RE: SUBMISSION ON DART + WEST ON BEHALF OF SPENCER PLACE DEVELOPMENT COMPANY LIMITED

ABP Ref. NA29S.314232

Description - DART+ West Railway Order - Dublin City to Maynooth and M3 Parkway

### STATIONS DESIGN SPENCER DOCK STATION STATION LOCATION

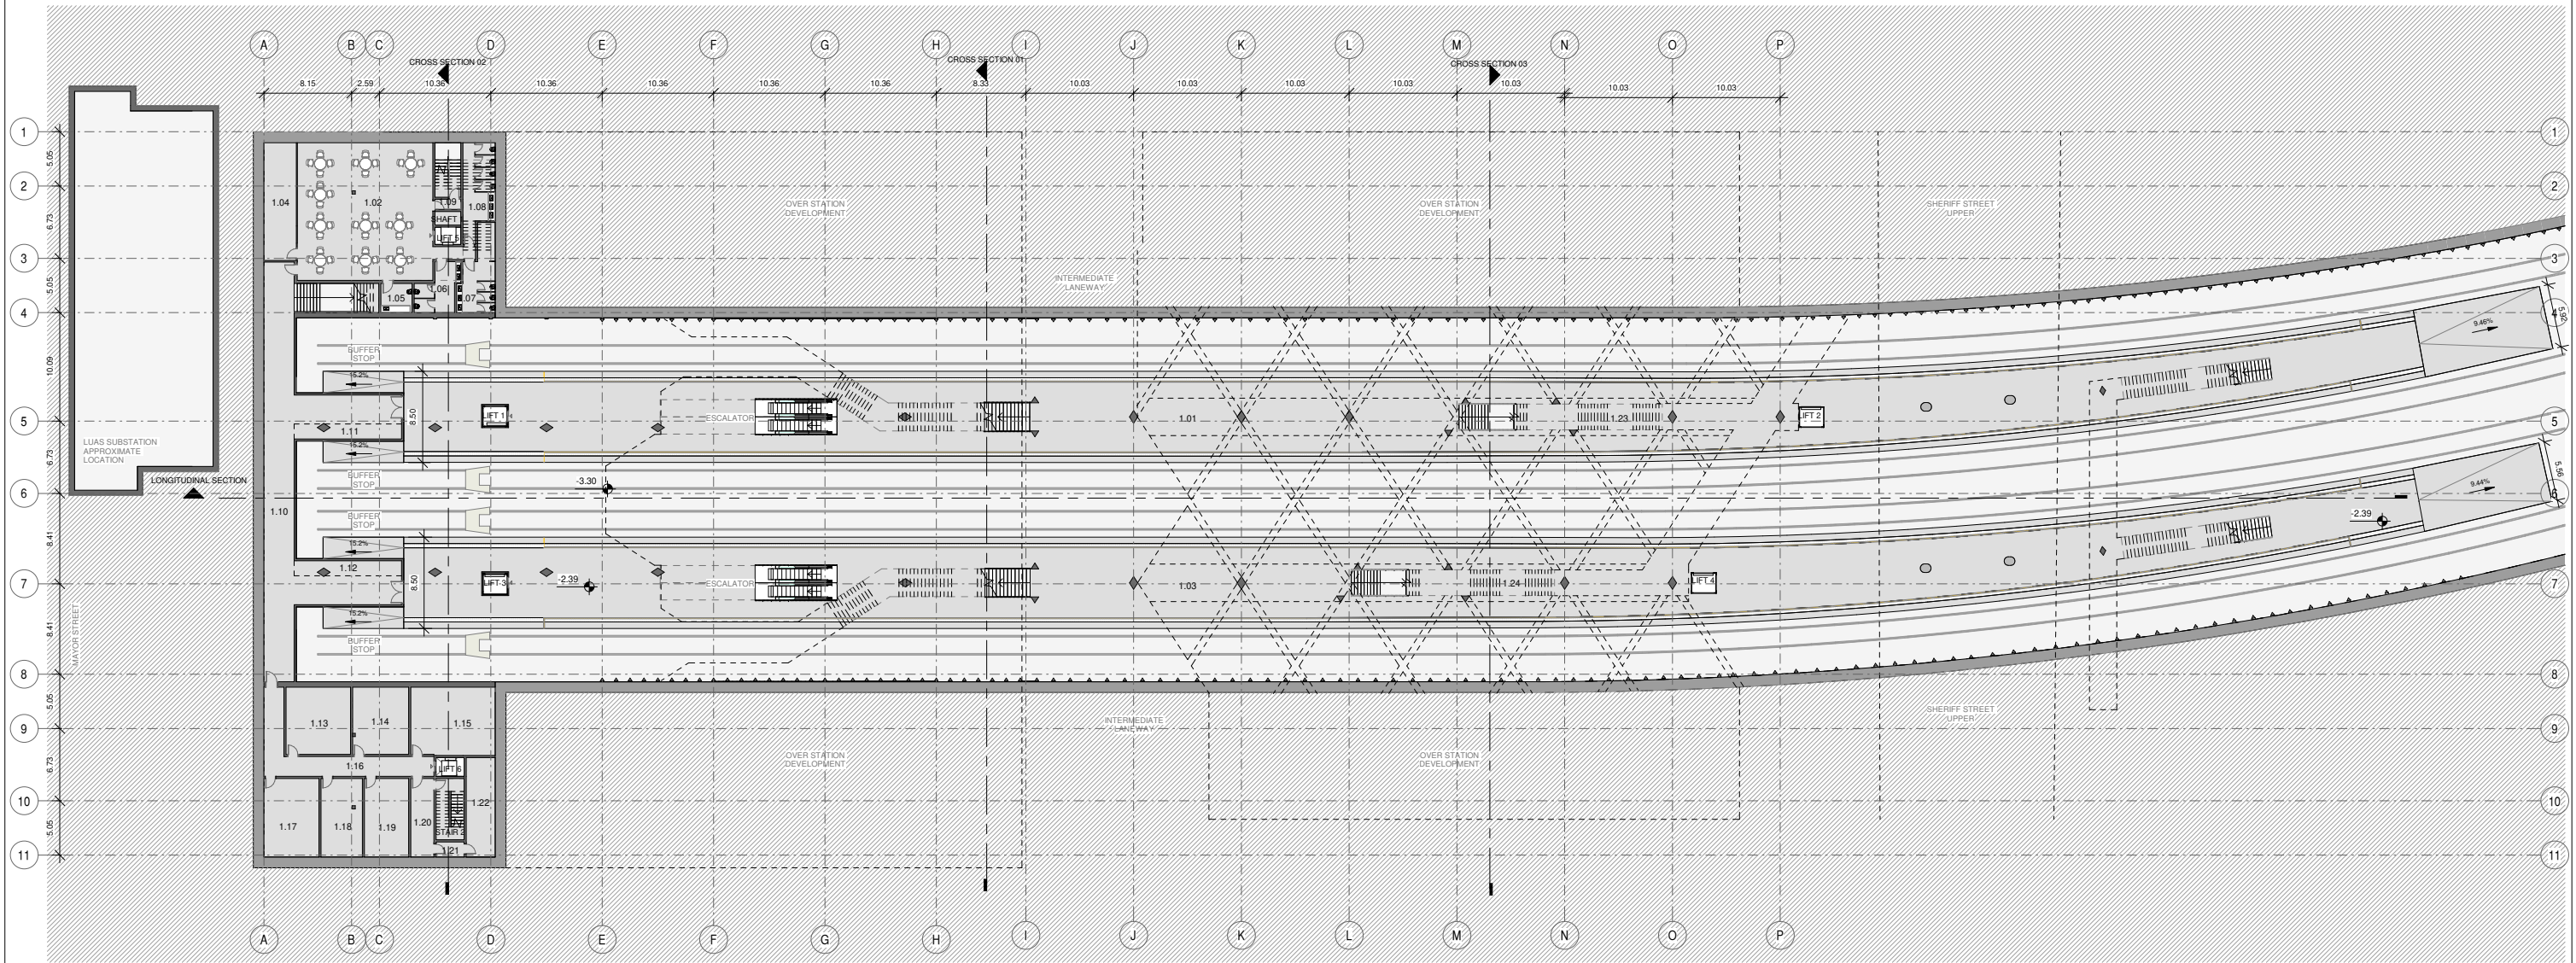
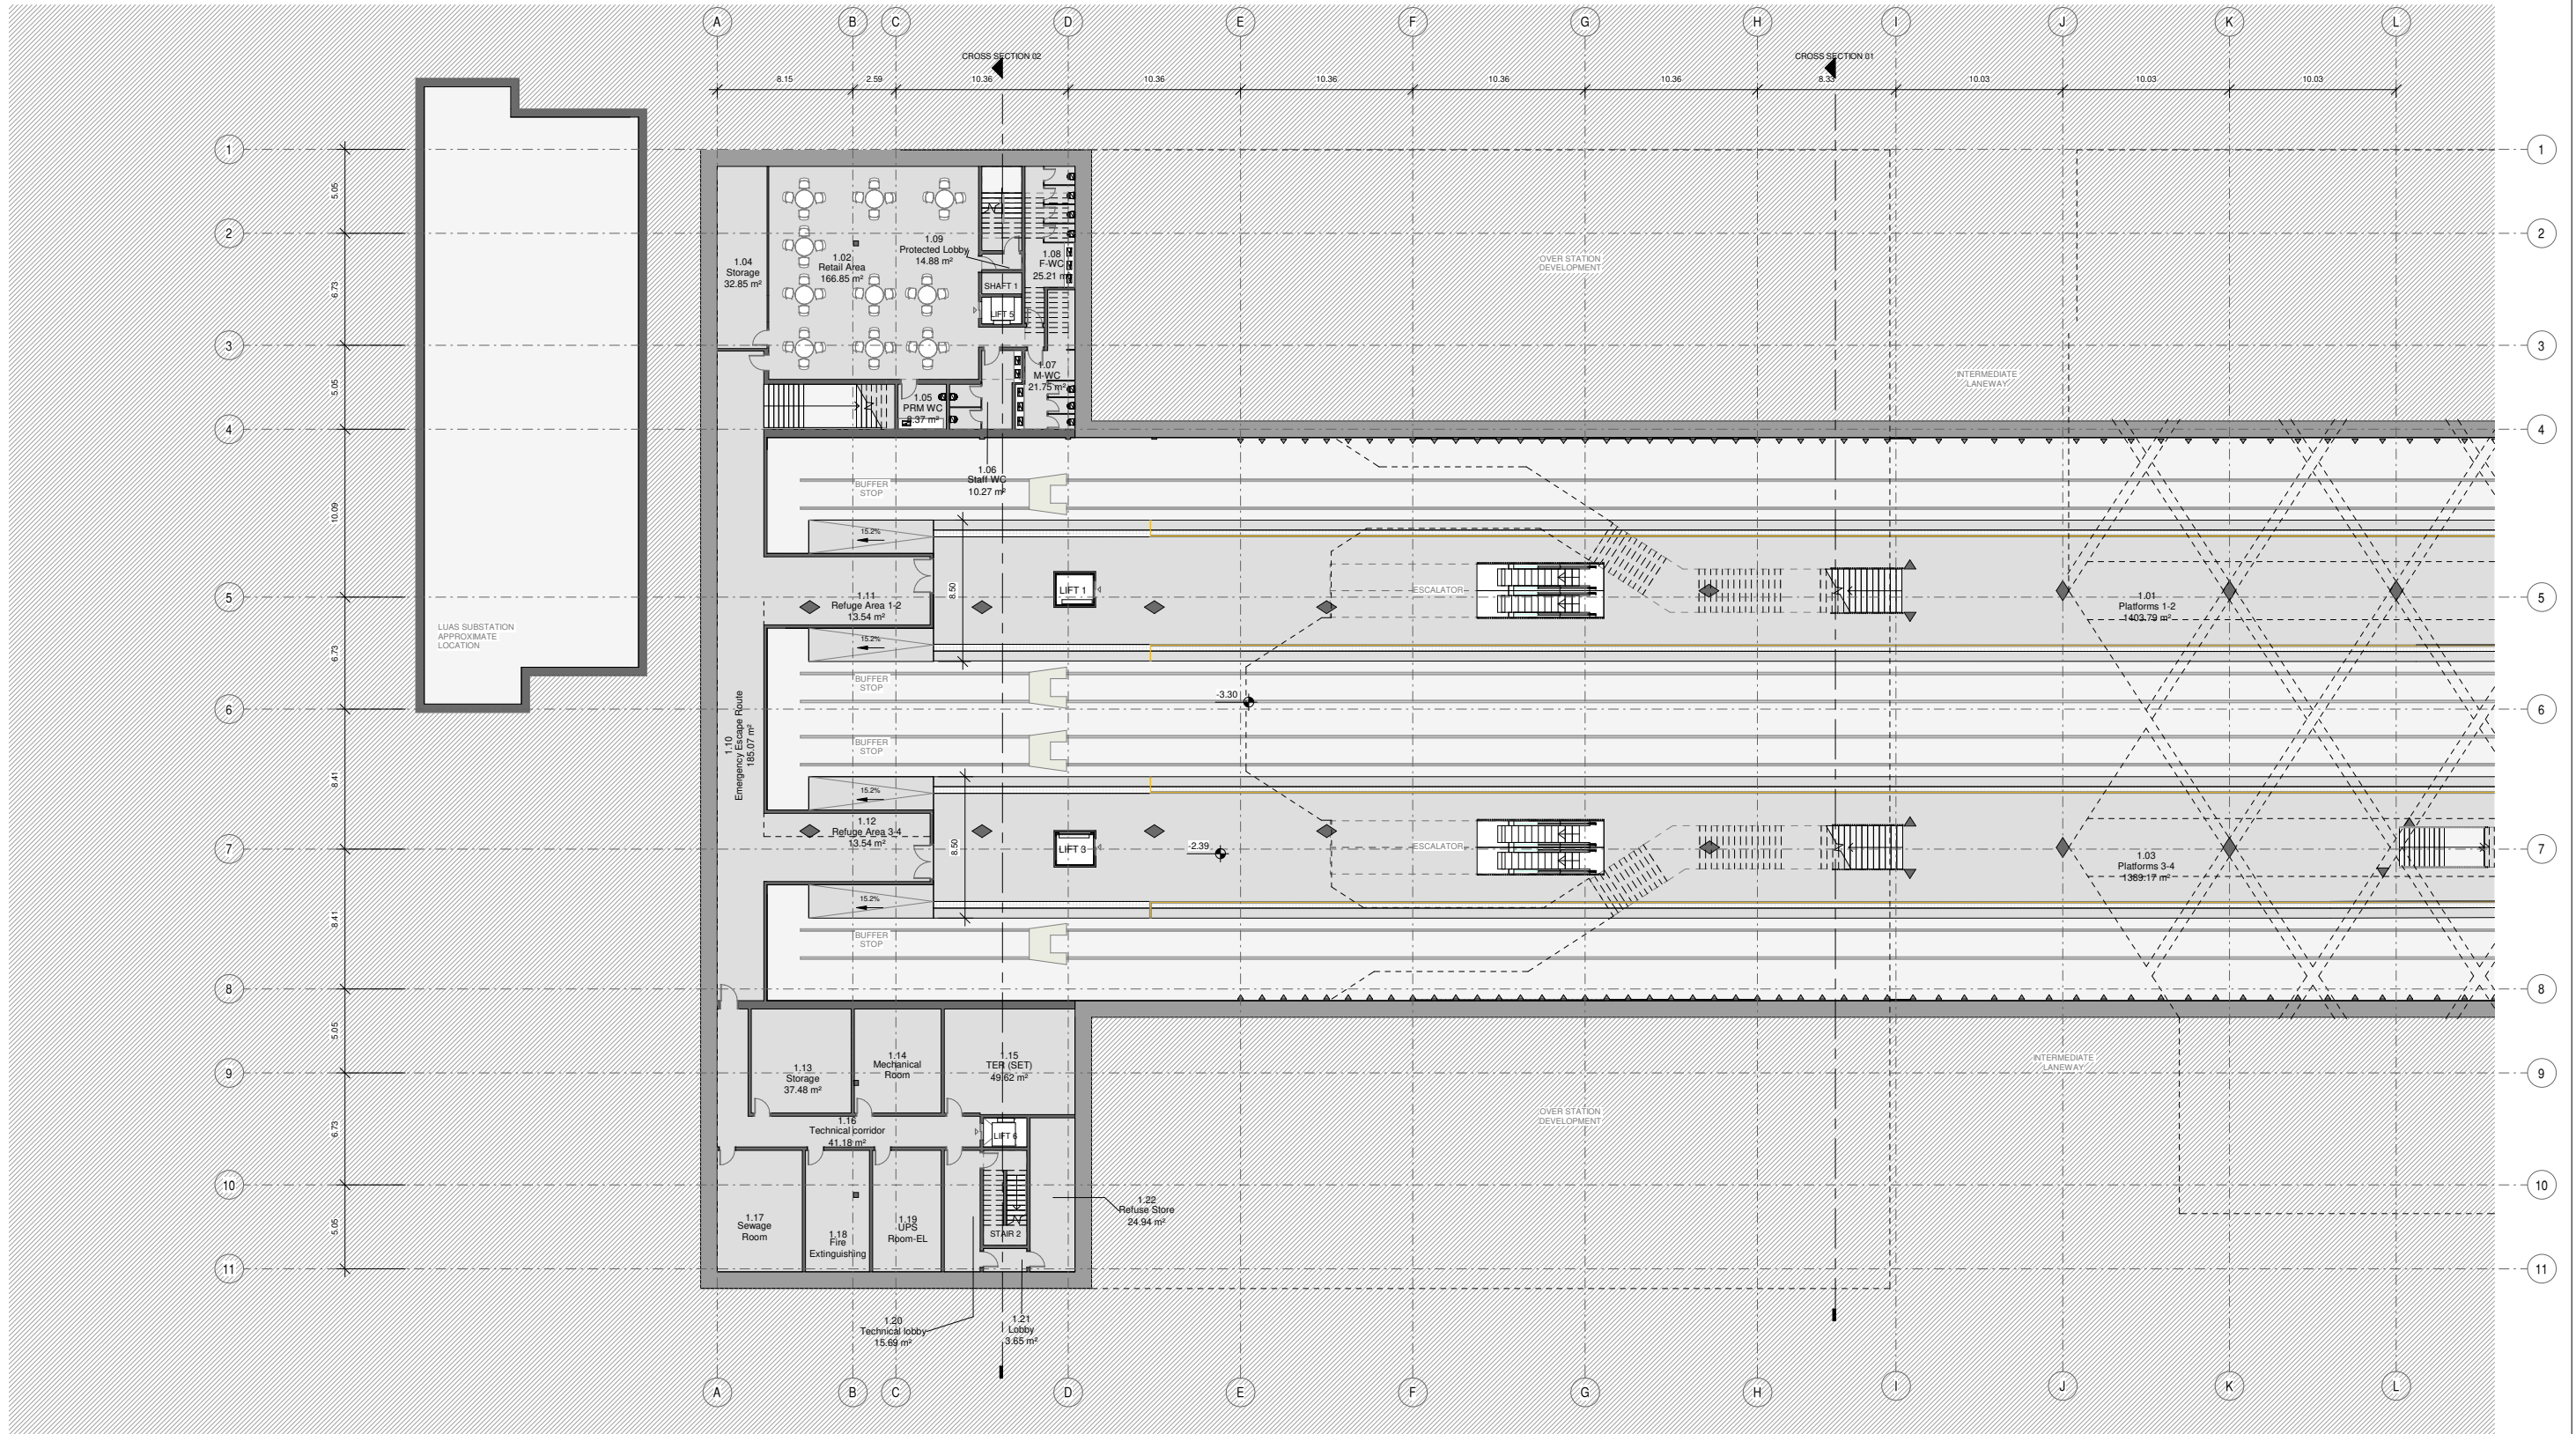
Our client also wishes to highlight the difficulties in assessing the proposals from the documentation submitted. The drawings relevant to Spencer Dock, do not show separation distances, or the dimensions of areas proposed for temporary and permanent land take. Furthermore, it is not clear from the information submitted, the purpose of the temporary land acquisitions and the nature and arising restrictions of permanent subterranean acquisitions. Our client would welcome further information in this respect, and an opportunity to further comment.

There is therefore clear provision in the statutory Planning Scheme for a 6 storey commercial / 7 storey residential development on the location of our clients lands in Block 2A, permissible on confirmation of the location of the station. The applicant's drawings and Spencer Dock Station Design Report show a notional future over station development for Spencer Dock. Detail is provided as to how Block 2C may be developed; however, no such detail is shown for Block 2C, which is partly in our client's control.

Our client seeks further information from the applicant to demonstrate that the design of the Spencer Dock Station incorporates the required elements to facilitate future over station development, both on our client's land interest and as part of a wider more comprehensive approach to an over station development at Block 2C. If such provisions are not incorporated at this stage, the proposals may prevent such appropriate future development, contrary to the provisions of the Planning Scheme.

Further, clarity is required on the nature of the subterranean acquisition to the east of the station building, and the restrictions on subterranean works which would facilitate over station development or development adjacent the station. This is considered essential to enable the Board to properly address whether the proposed scheme the subject of the Railway Order application can be considered to be consistent with the proper planning and sustainable development of the area.
